Application Reference: 6/2019/3216/COND

Proposed development at: 12 Tolmers Gardens, Cuffley, Potters Bar, EN6 4JE

Proposal: Submission of details pursuant to condition 1 (sample of materials) 2 (crown roof details) 3 (scheme of accessible housing) 4 (balcony flank screens) 5 (hard and soft landscaping works) 7 (cycle store) 8 (bin store) and 9 (shared surface access) on planning permission 6/2018/3125/FULL

**job drwg. no:** JW820-C4-142 **rev:**

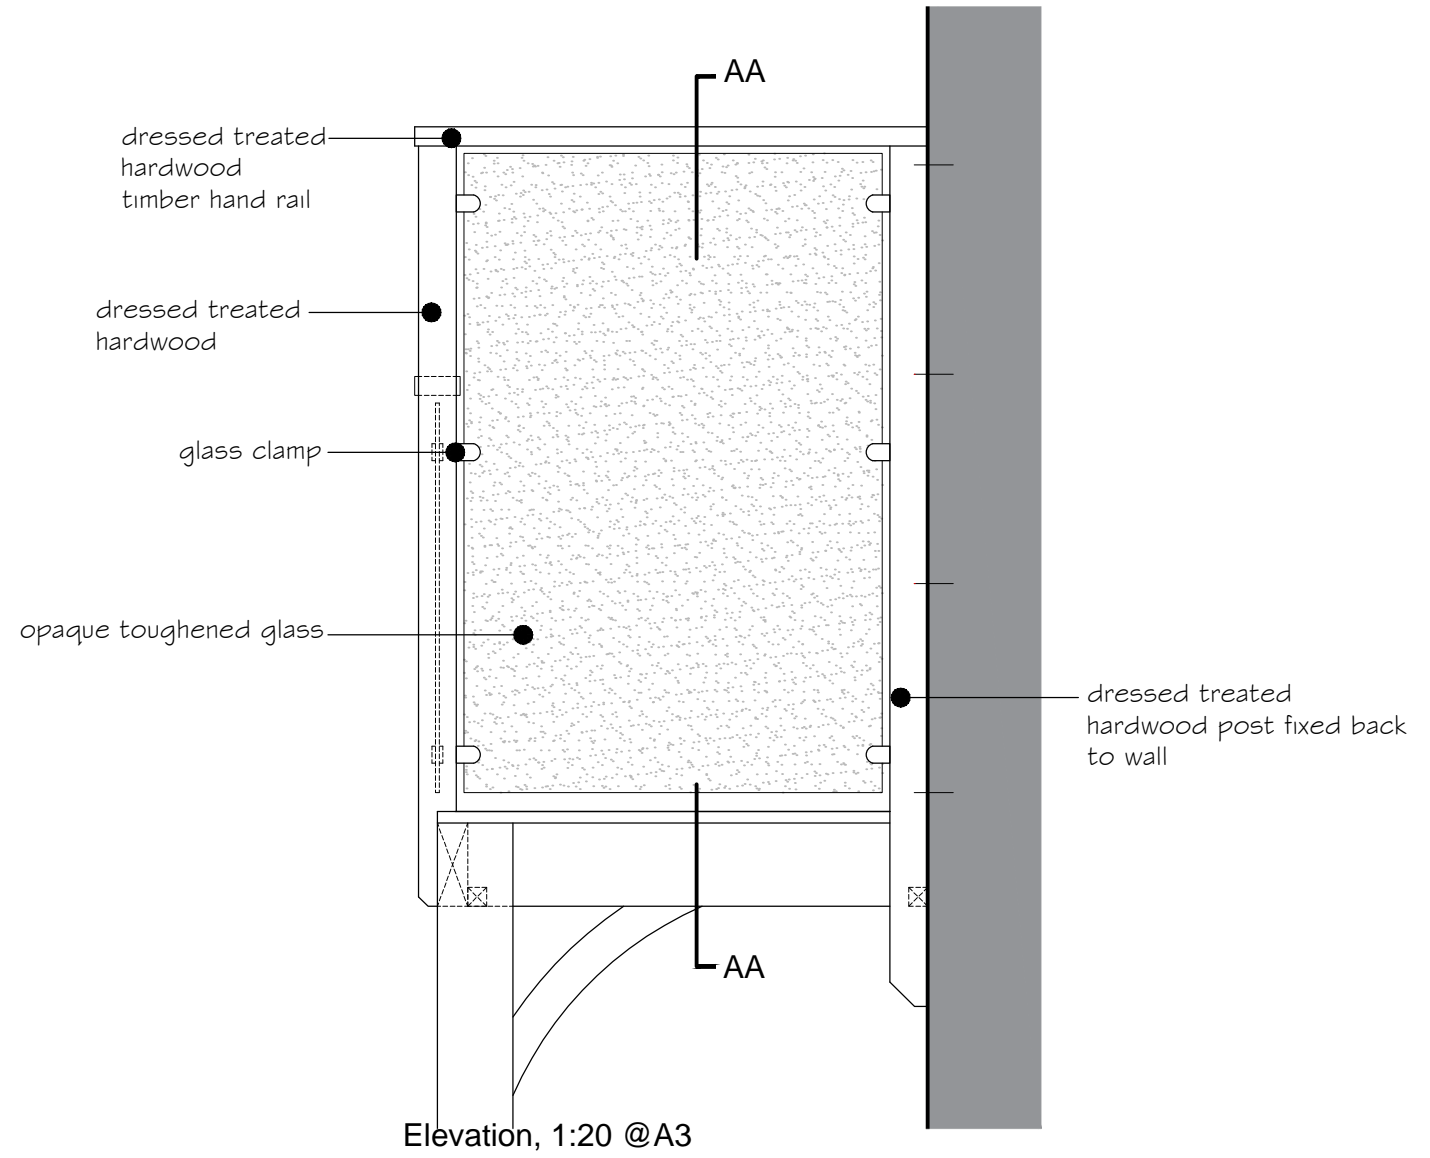
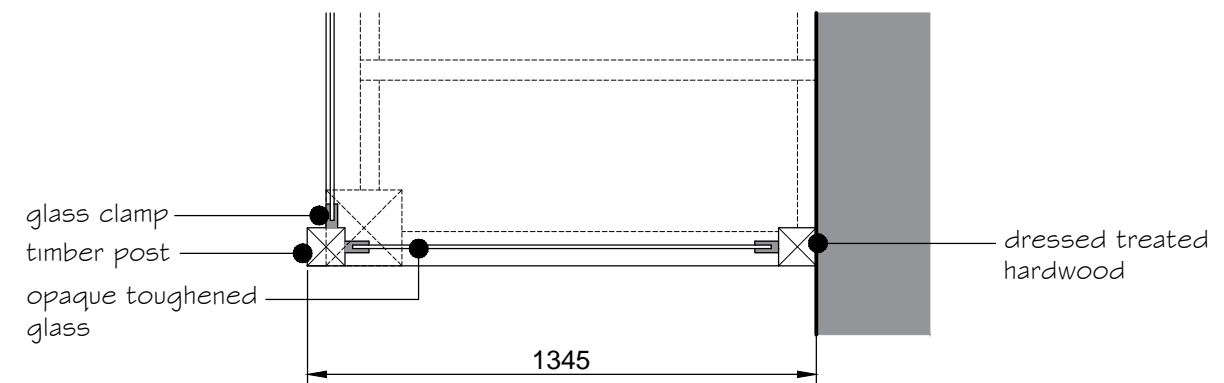
Submitted drawing number: JW820-C4-142, shows acceptable flanks screens for the balcony associated with Flat 5.

**job dwg. no.:** jw820-C5/9-143 **rev:** A

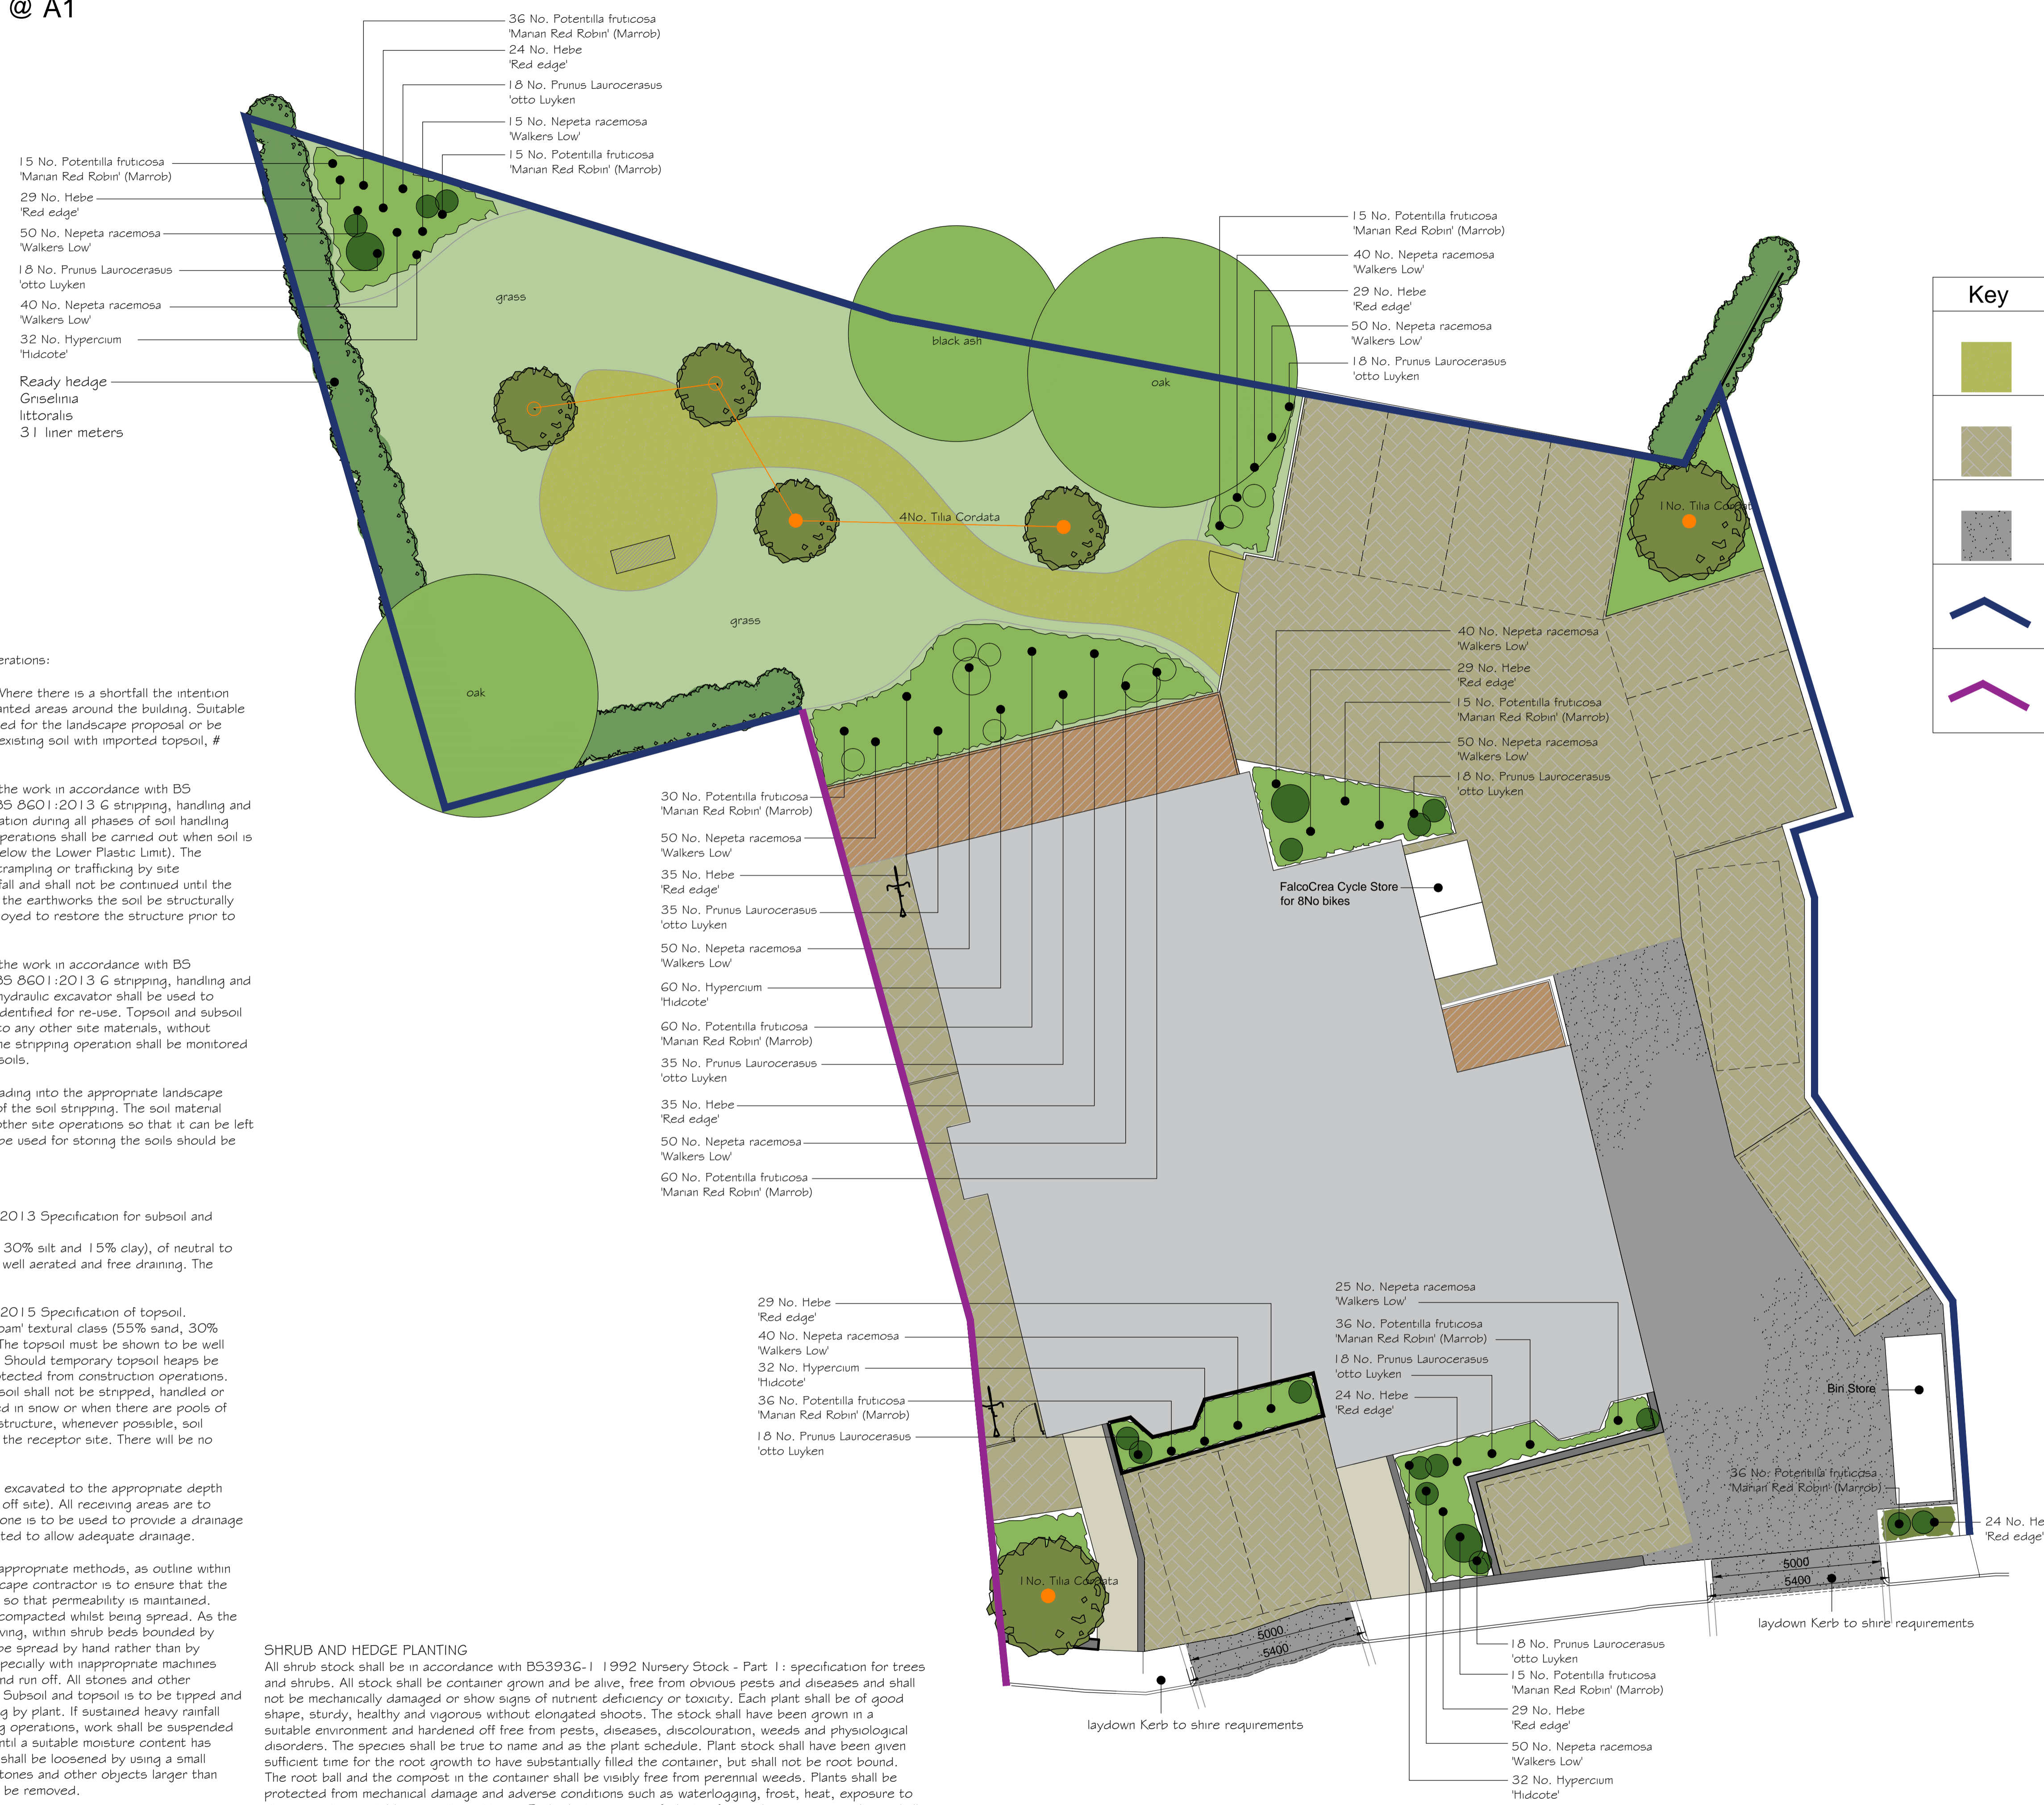
Submitted drawing number: jw820C59143 Rev B, includes acceptable soft and hard landscaping details and the submitted Method Statement satisfies part (c).

Submitted drawing number: jw820C59143 Rev B, shows the shared surface access to the acceptable width of 5 metres.

job drwg. no: JW820-C8-140
rev:

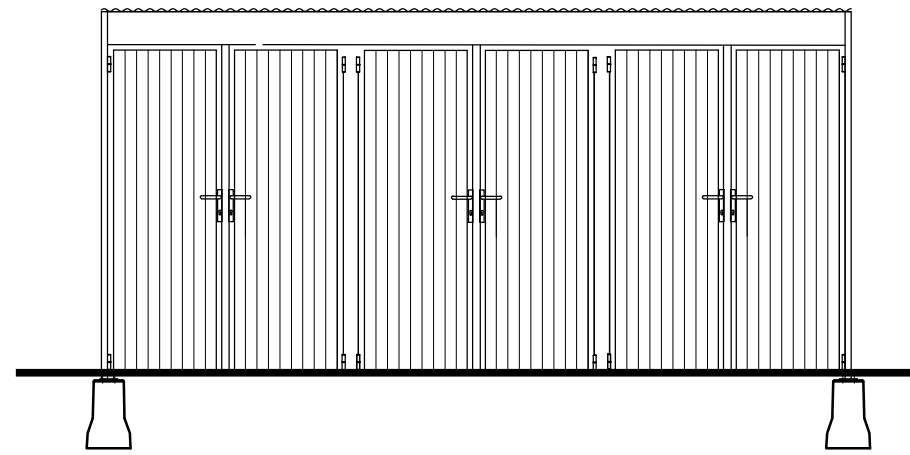
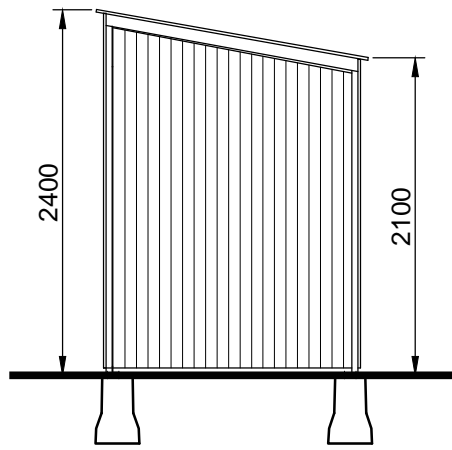
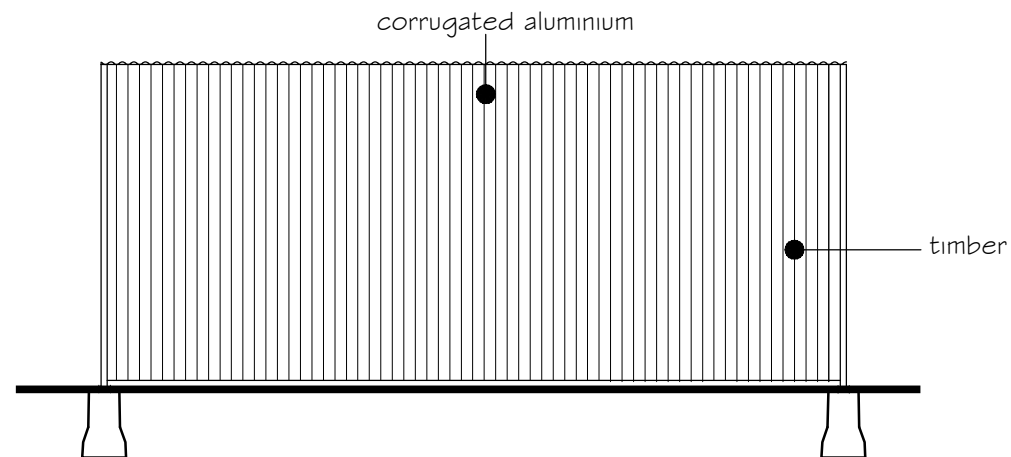
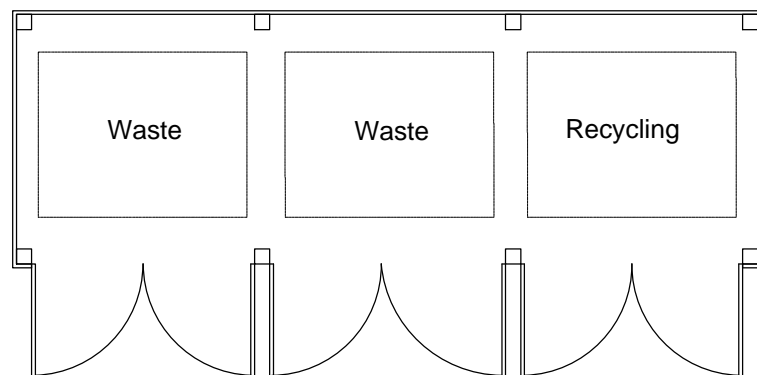
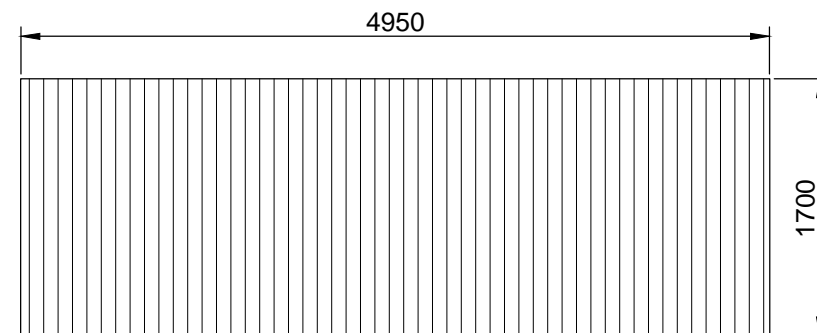
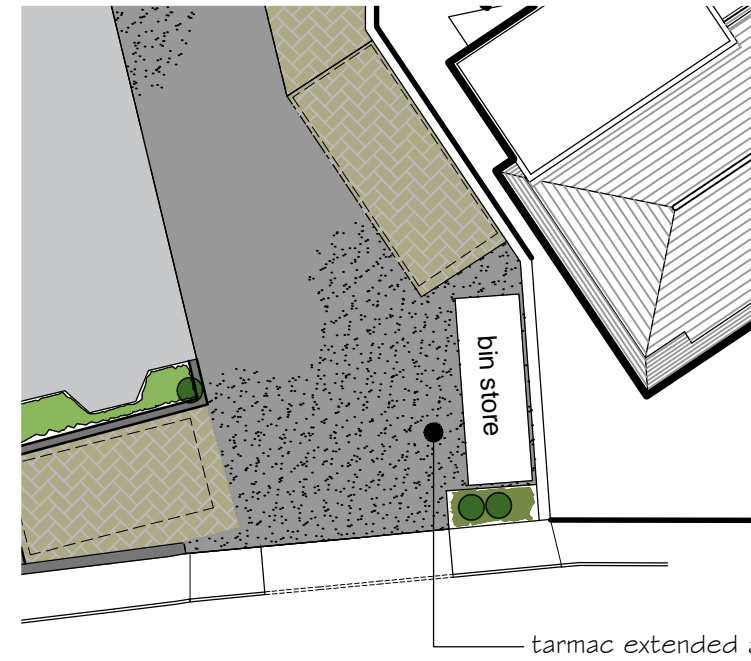
Submitted drawing number: JW820-C8-140 shows acceptable details.
